Item No. **Report of the Head of Planning, Transportation and Regeneration**

Address 28 HOWLETTS LANE RUISLIP

Development: Single storey rear extension, single storey front/side extension, porch to front and conversion of roof space to habitable use to include a rear dormer, 2 front roof lights and 1 side roof light.

LBH Ref Nos: **22663/APP/2020/52**

proposed front elevation

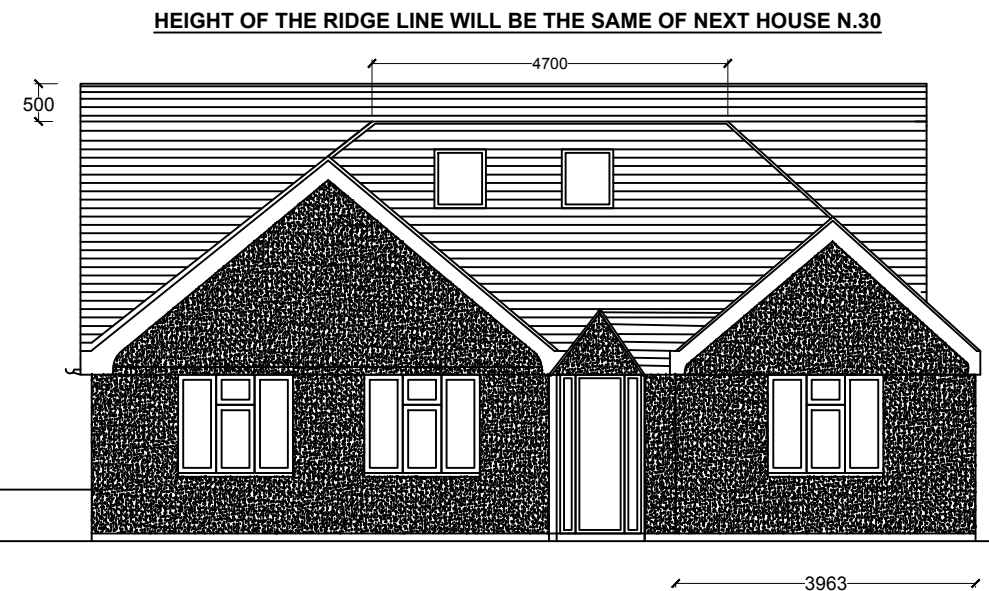
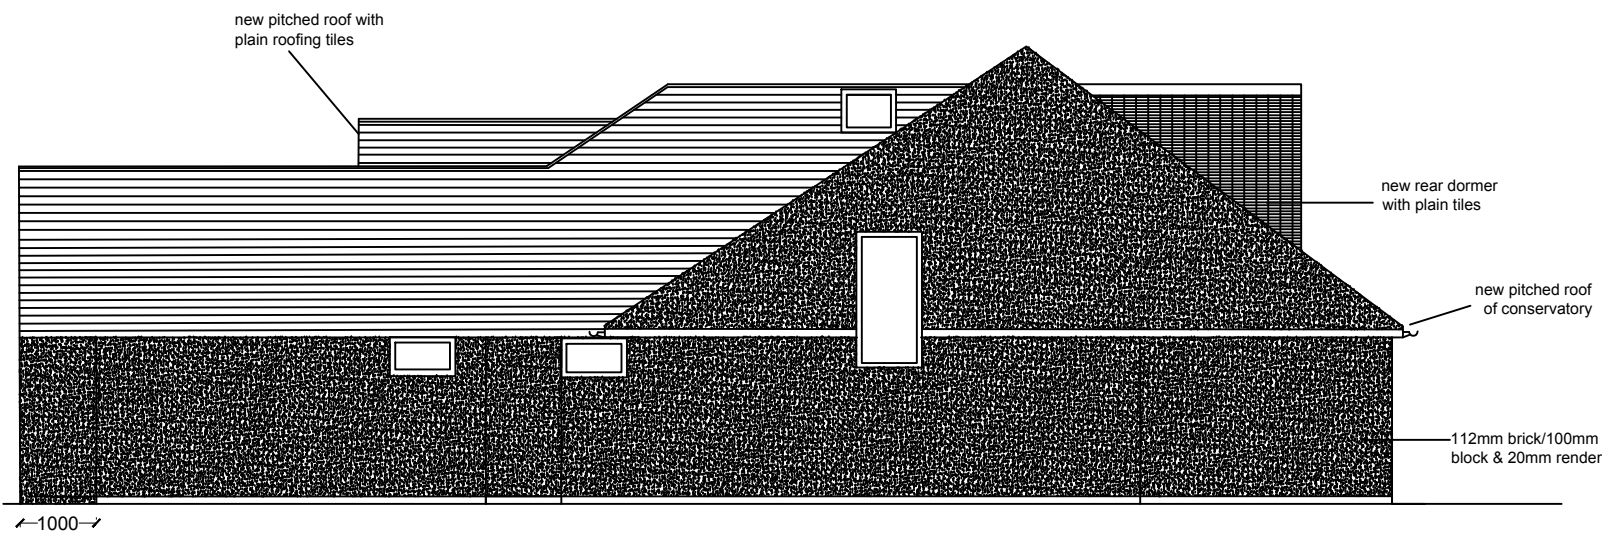
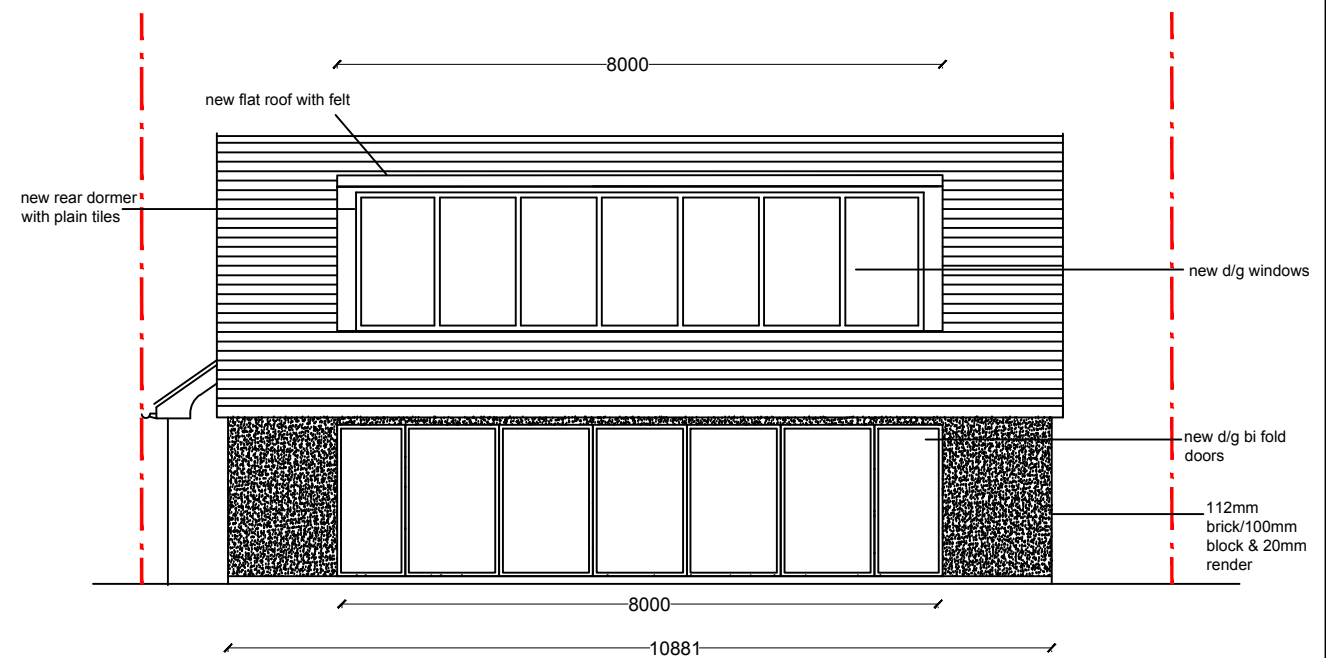
The property benefits from a front canopy which will be demolished as a result of the proposal. The proposed single storey front porch would measure 1.5m in width, 1.5m in depth with a height of 3.1m respectively. The proposed single storey front/side extension would measure 3.97m, 7.2m and 4.4m in width, depth and height respectively. Due to the sufficient set back distance of the host dwelling from the front boundary, the proposed single storey front/side extension would not appear cramped and would satisfactorily integrate with the character and appearance of the host dwelling and the visual amenities of the street scene and surrounding area.

In addition it is considered that the proposed roof profile should match that of the existing roof. This would not be possible as the property would have a crown roof with two high front gabled roofs. Any alterations should respect such local distinctiveness. Policy DMHD 1 suggests that raising of a main roof above the existing ridgeline of a house will generally not be supported. The proposed roof would be 0.5m higher than existing roof. Also two front gable roofs will be 5.1m and 4.3m high at southern side and northern side respectively which would be higher than existing gable roofs by 0.4m and 0.8m respectively. The proposal would fail to be subordinate to the original property and wider area. This results in an unbalanced appearance between the other dwellings in wider area and would impact unduly on the character and appearance of the existing and adjoining properties and the visual amenities of the street scene and the area in general.

However it is considered that the development is not characteristic in the streetscene and it is considered that the proposed development would be highly visible when travelling in both directions along Howletts Lane. Furthermore, regard must be given to the most recent policy documents. Therefore, the development is considered unacceptable as it fails to comply with the requirements of Policies DMHD 1, DMHB 11 and 12 of the Local Plan: Part Two - Development Management Policies (2020).

proposed roof plan

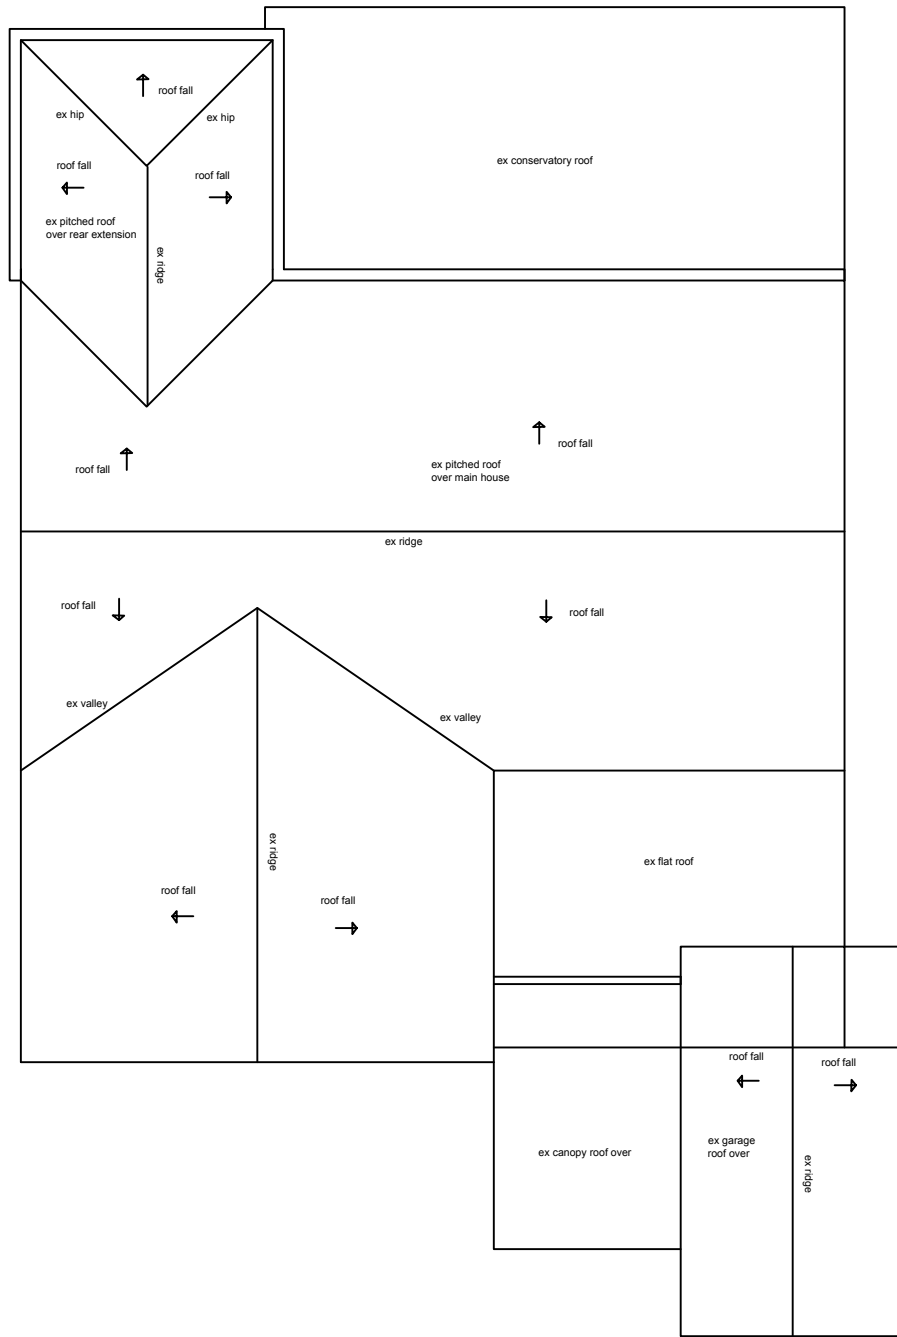
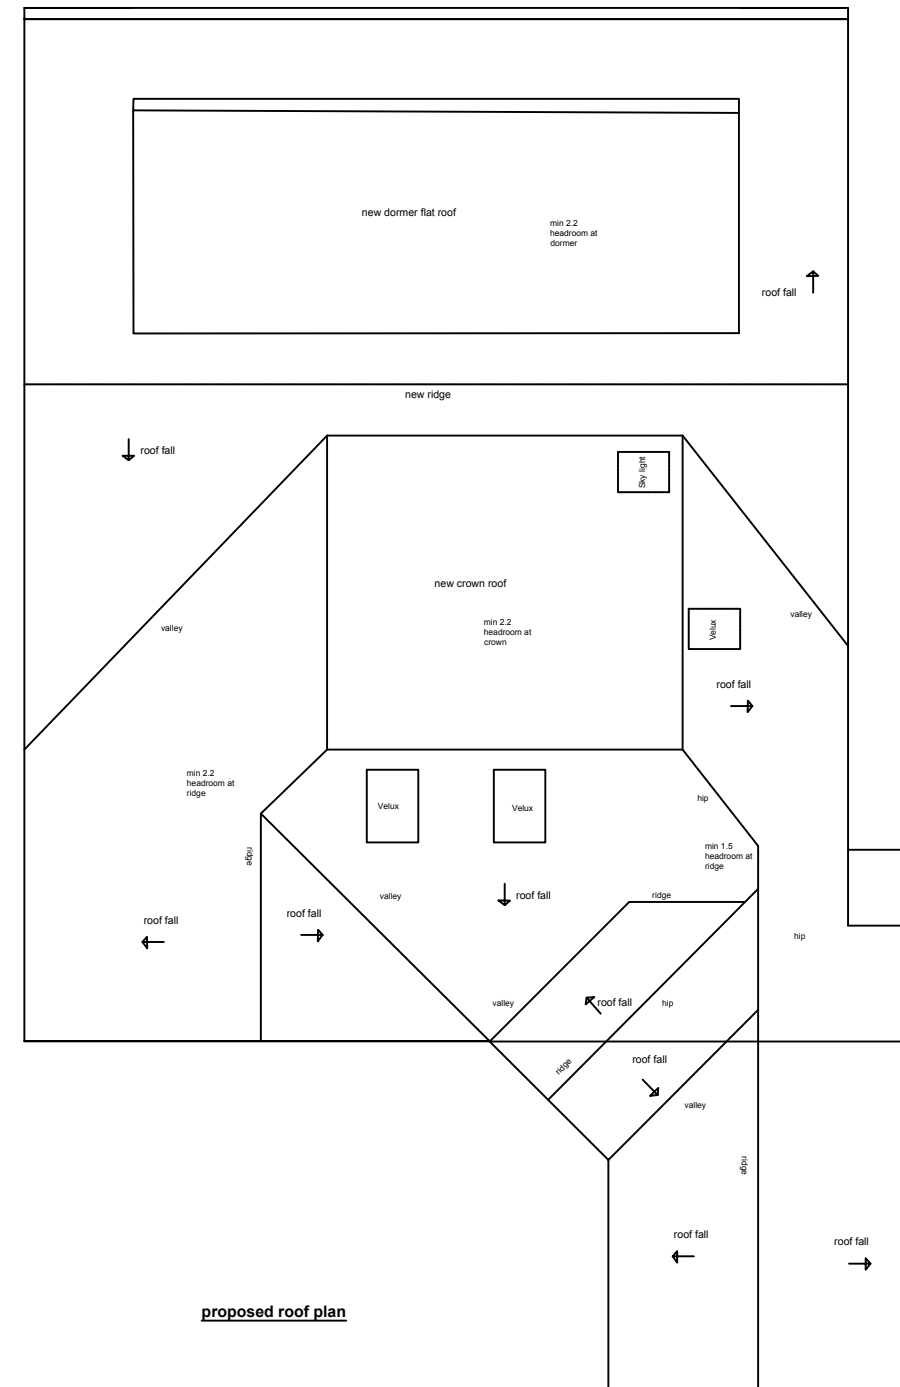
The proposed dormer would be 8 m wide, 2m high and 3 m deep. The width of the proposed rear dormer would be more than 2 thirds of the width of the original roof (11.18m). As such the size of the proposed rear dormer would not be considered sufficient to appear secondary or proportionate to the main roof slope and would have a harmful impact on the character and appearance of the existing house and street scene. Accordingly it is considered that the proposed dormer does not comply with DMHD 1 of the Development Management Policies (2020).

The roof alteration and extensions, by reason of the provision of a crown roof, an increase in ridge height and the size, scale, bulk and design of the rear dormer roof extension would fail to harmonise with the architectural composition of the original detached bungalow, would be detrimental to the character, appearance and visual amenities of the street scene and the surrounding area. Therefore the proposal would be contrary to Policy DMHD 1, DMHB 11 and DMHB 12 of the Hillingdon Local Plan: Part Two - Development Management Policies (2020).
